Dated: 6 October 2020

**Aquind Interconnector**  
**Local Impact Statement submitted by**  
**Winchester City Council**

Aquid Countryside Option

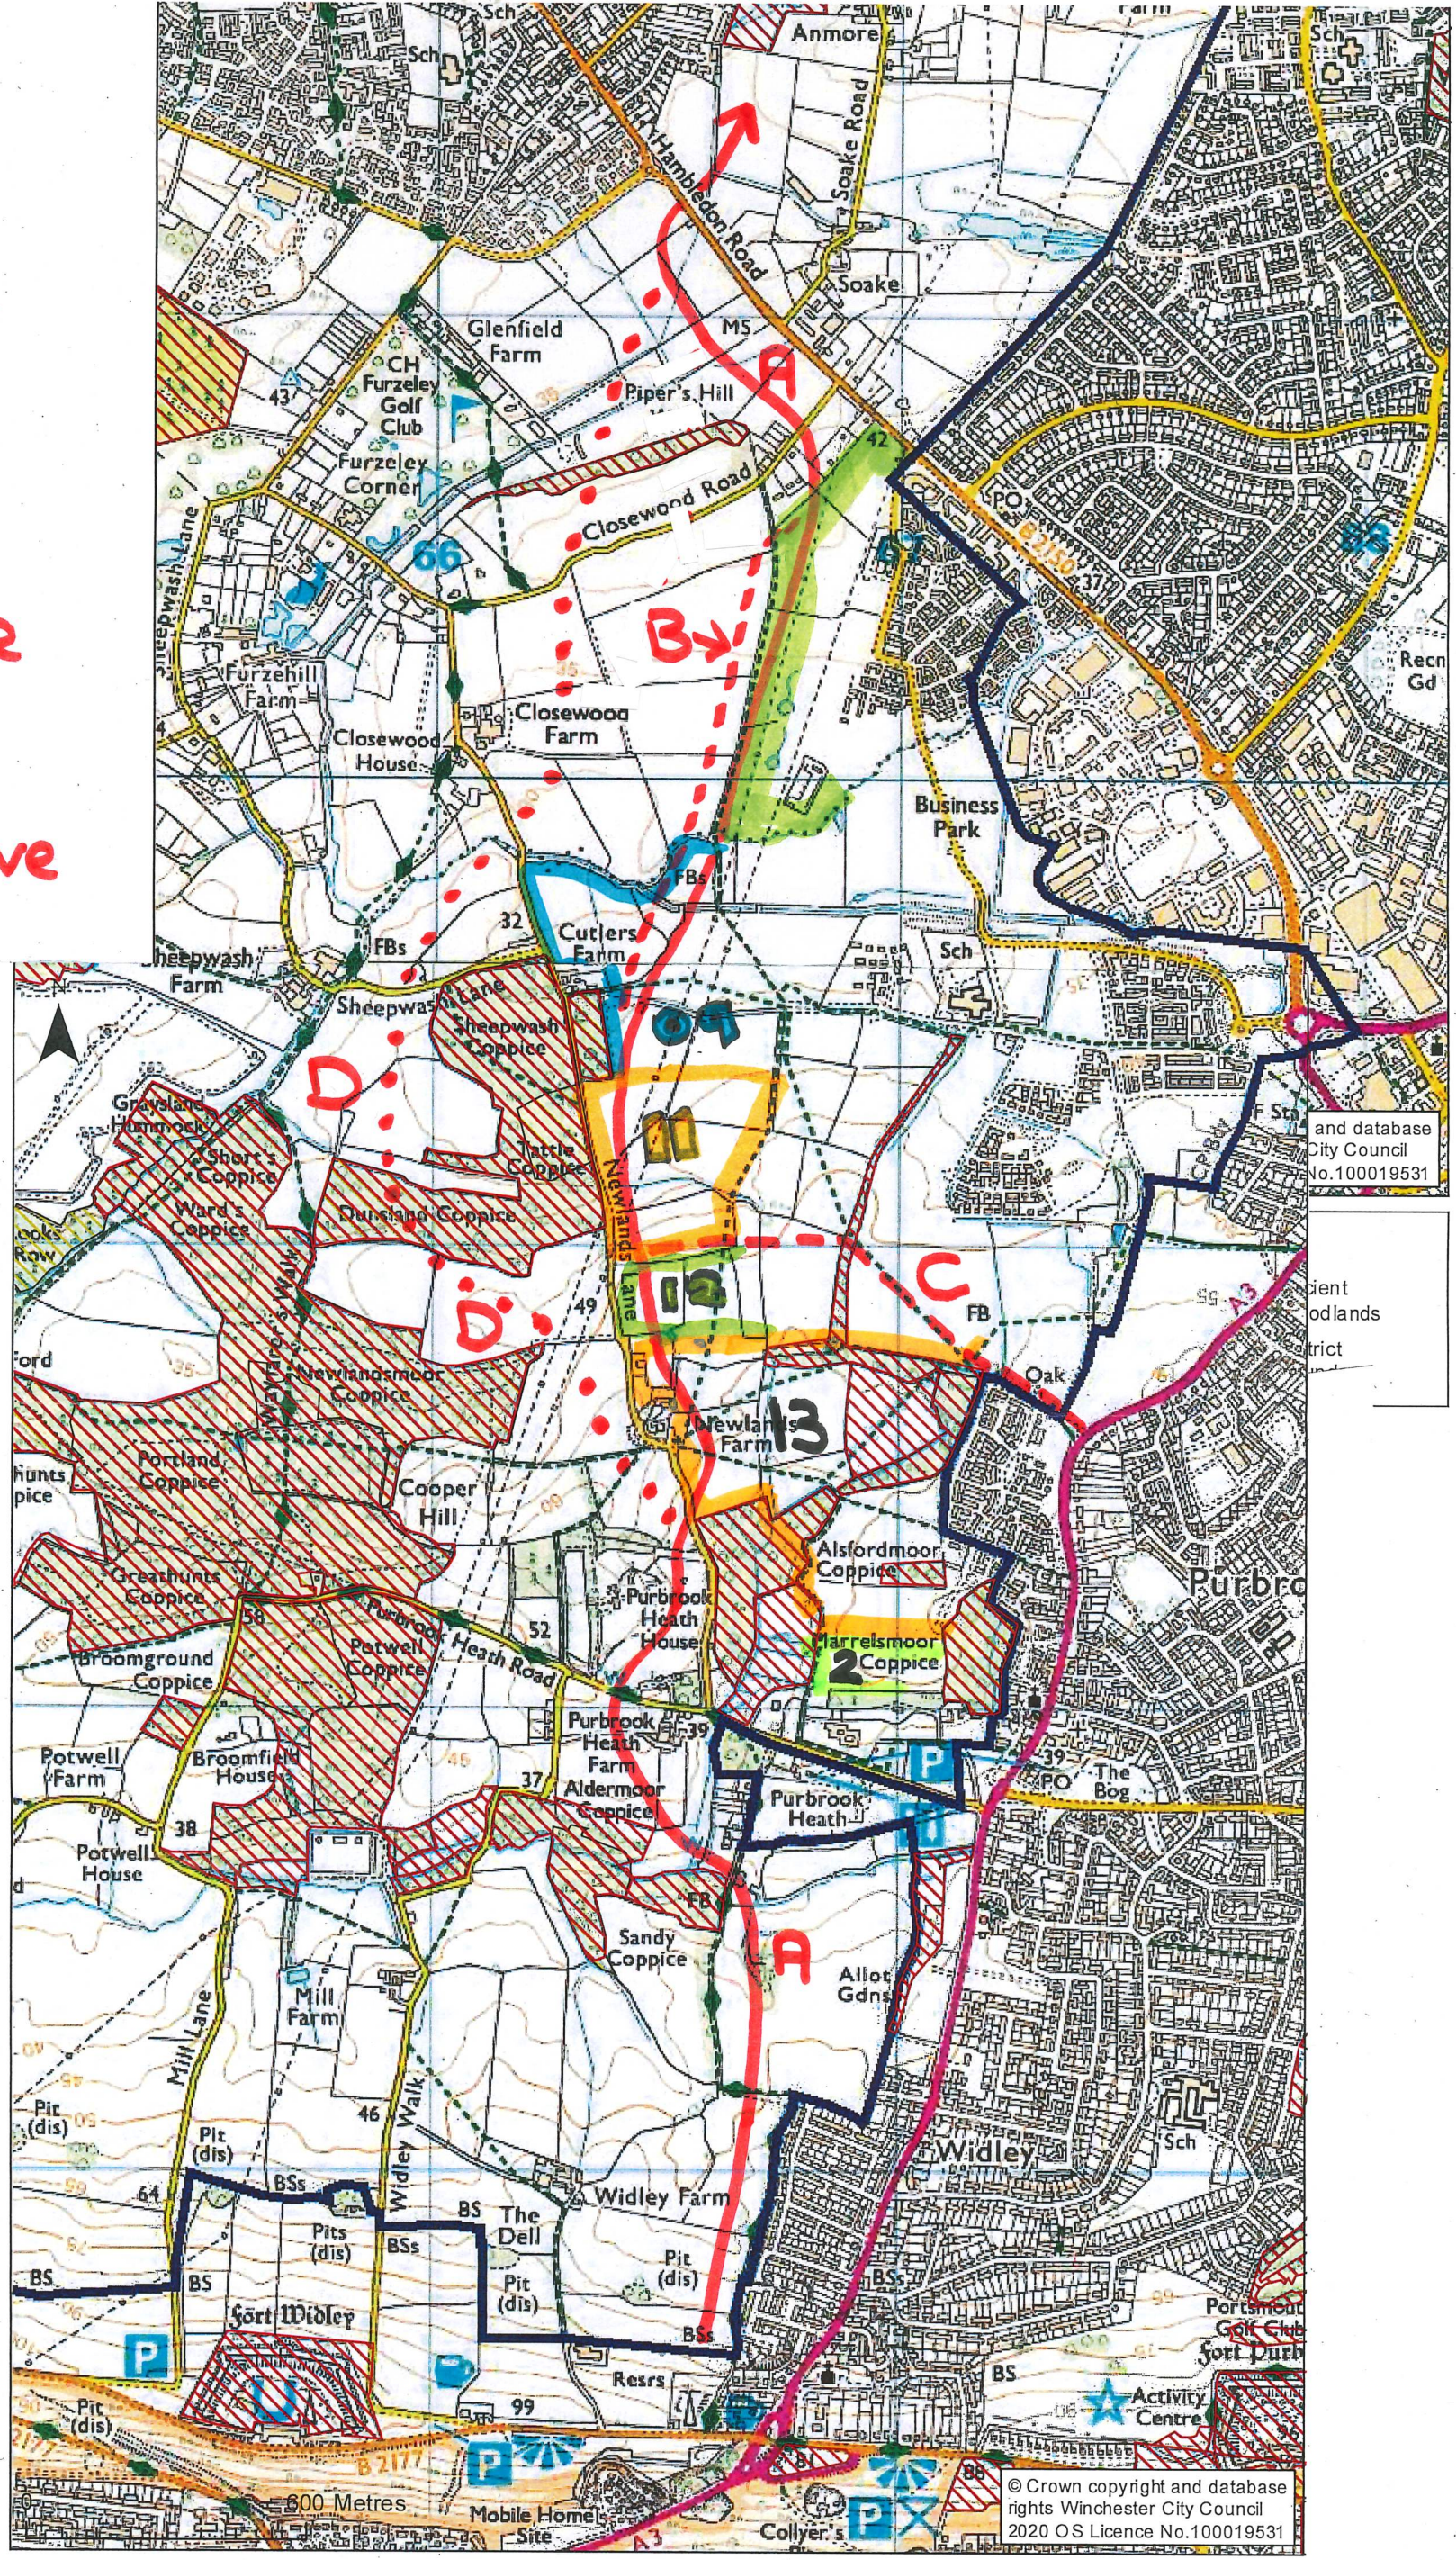
- 4.6.4.5 The study has considered two routes which are annotated on the attached plan as route A and route D. Route A avoids any SINC or ancient woodland and runs parallel to the over head pylon line. Where it runs through the West Waterlooville Development Area (WWDA) it would utilise what is intended to be open space. Route B is a slight deviation, avoiding the WWDA and move further away from the overhead route. By contrast route D avoids the WWDA completely. However, it would need to negotiate two designated woodlands. This could be achieved by horizontal drilling. The second jump off point part way up the A3 is identified as route C on the plan. This route runs west and could join route A, or it could continue across the southern edge of the woodland and joint route D.

- 4.6.4.5 The conclusion of the preliminary desk top study is that the countryside route has merit and deserves a more thorough examination and comparative assessment against the road route. The Council notes that the examination of an alternative to the road route has the support of a number of other interested parties including Hampshire County Council, Havant BC and Newlands Parish Council.
